SUBMISSION SYDNEY METRO WEST

Critical State Significant Infrastructure Application

Rail Infrastructure, Station, Precincts & Operations EIS

MAY 2022

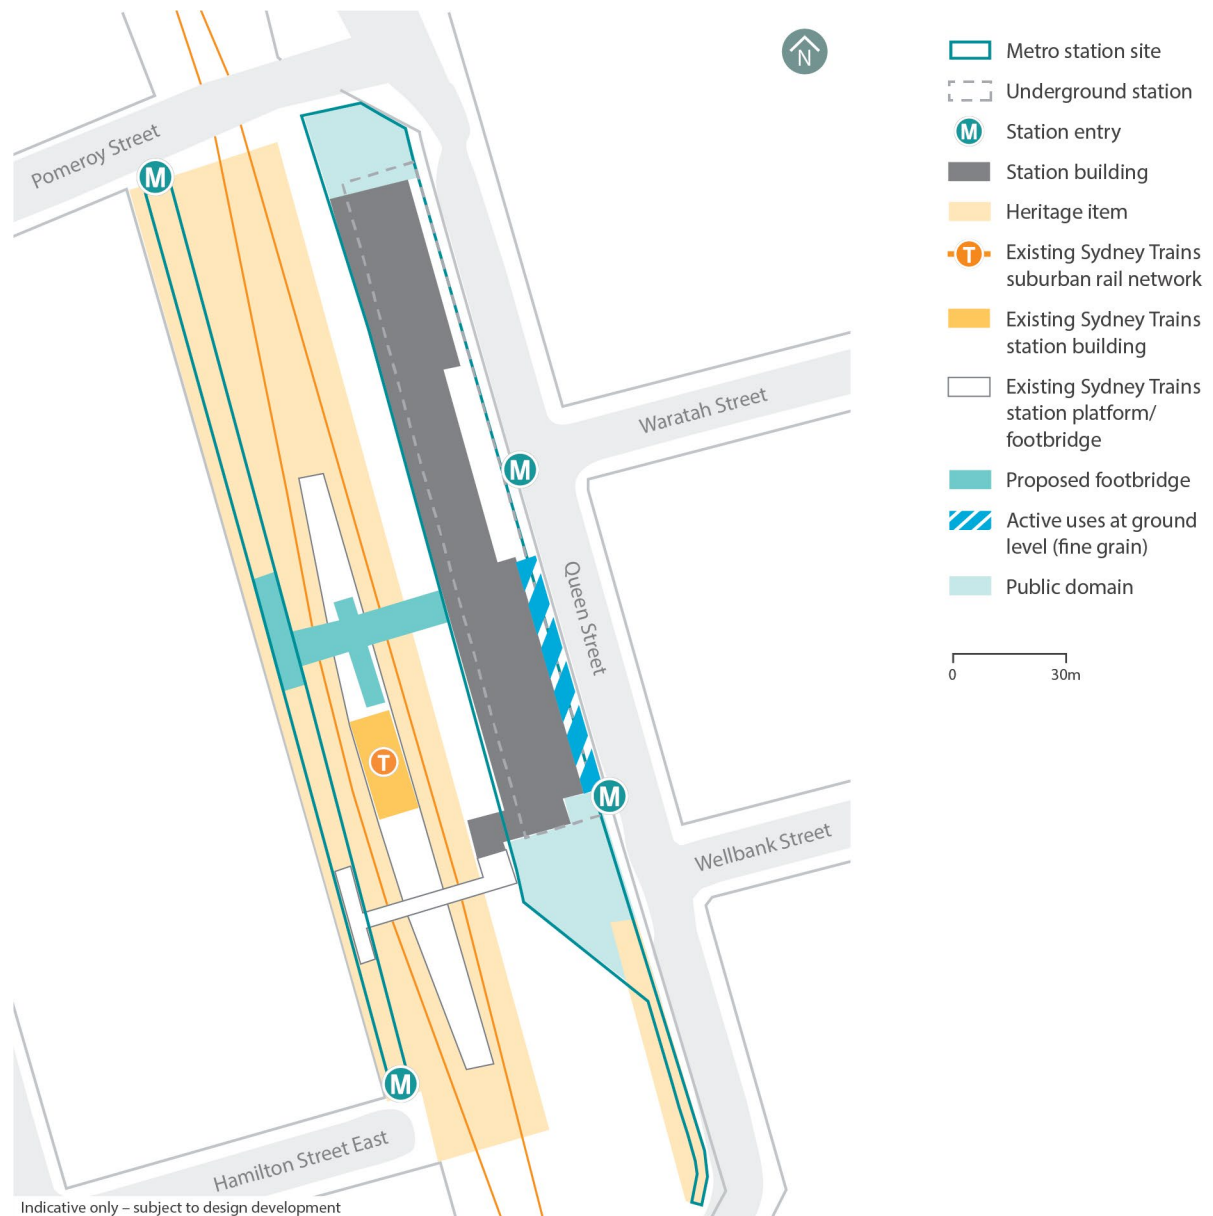
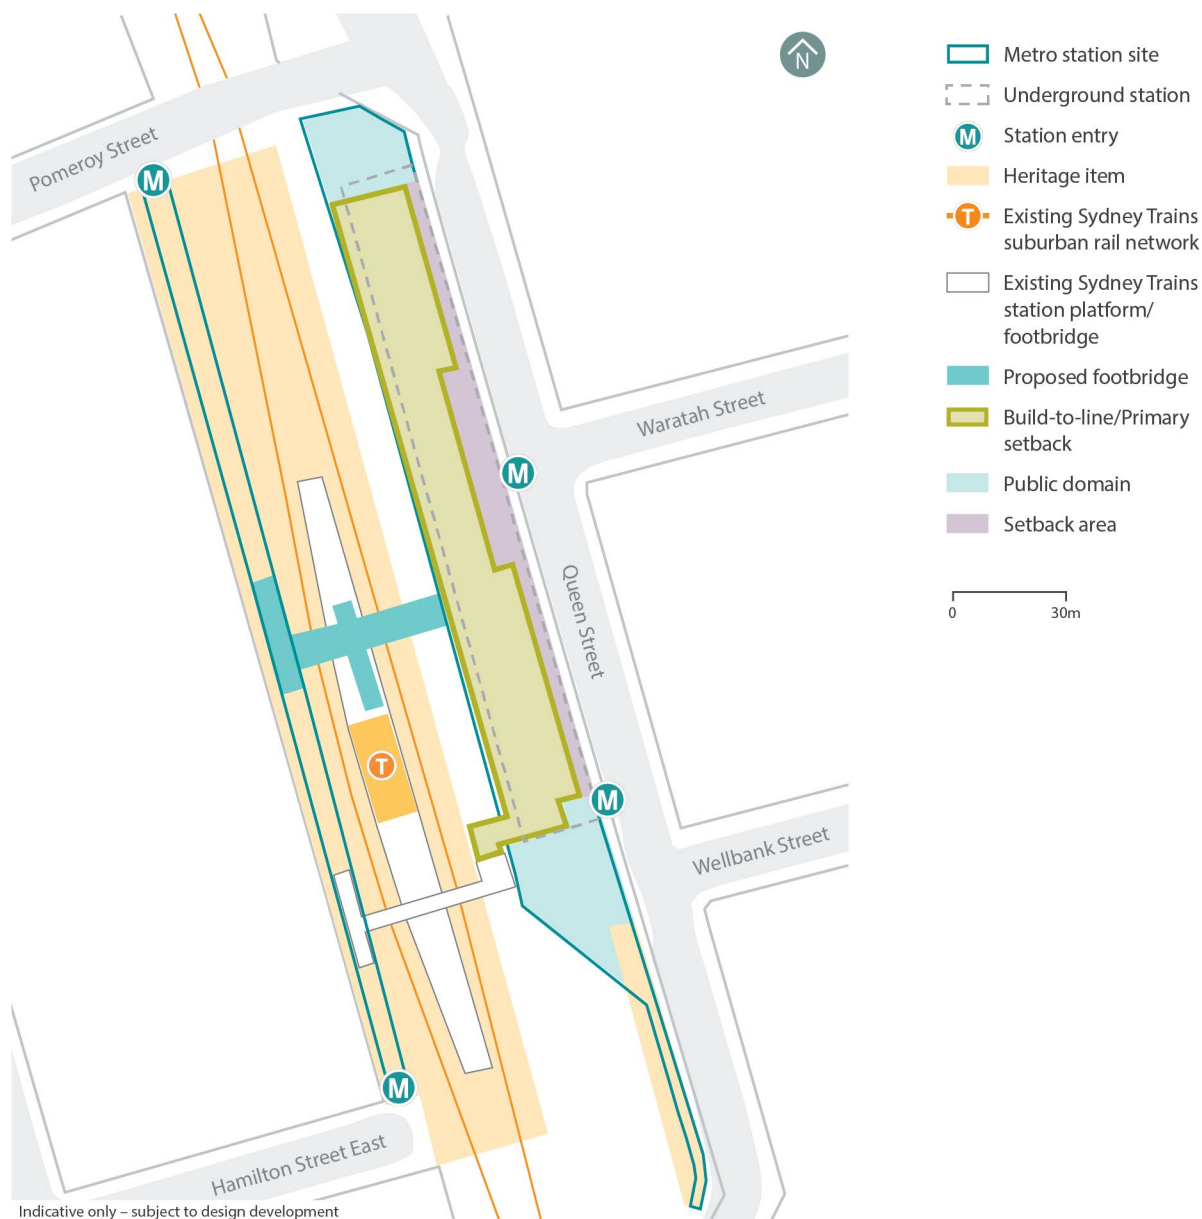
- The proposed design guidelines show public space fronting Pomeroy Street as part of the station development, however the long-section provided in Chapter 10 of the EIS shows that the station function fronting this public domain will be station services, offering no activated frontage to the identified public domain. The activation of this public domain will lead to significantly better safety and amenity outcomes and provide passive surveillance of Pomeroy Street and the associated walkway into the station.

- The area to the west of the station is currently zoned for high-density residential development and subject to urban renewal in the coming decades; and the commercial and entertainment area (Bakehouse Quarter) will also access the station from the west, placing greater emphasis on the western entry than shown by the current design, which is primarily east-facing. Given the constraints of the western side of the station, careful consideration relating to activation needs to be part of the design guidelines for this important access point.
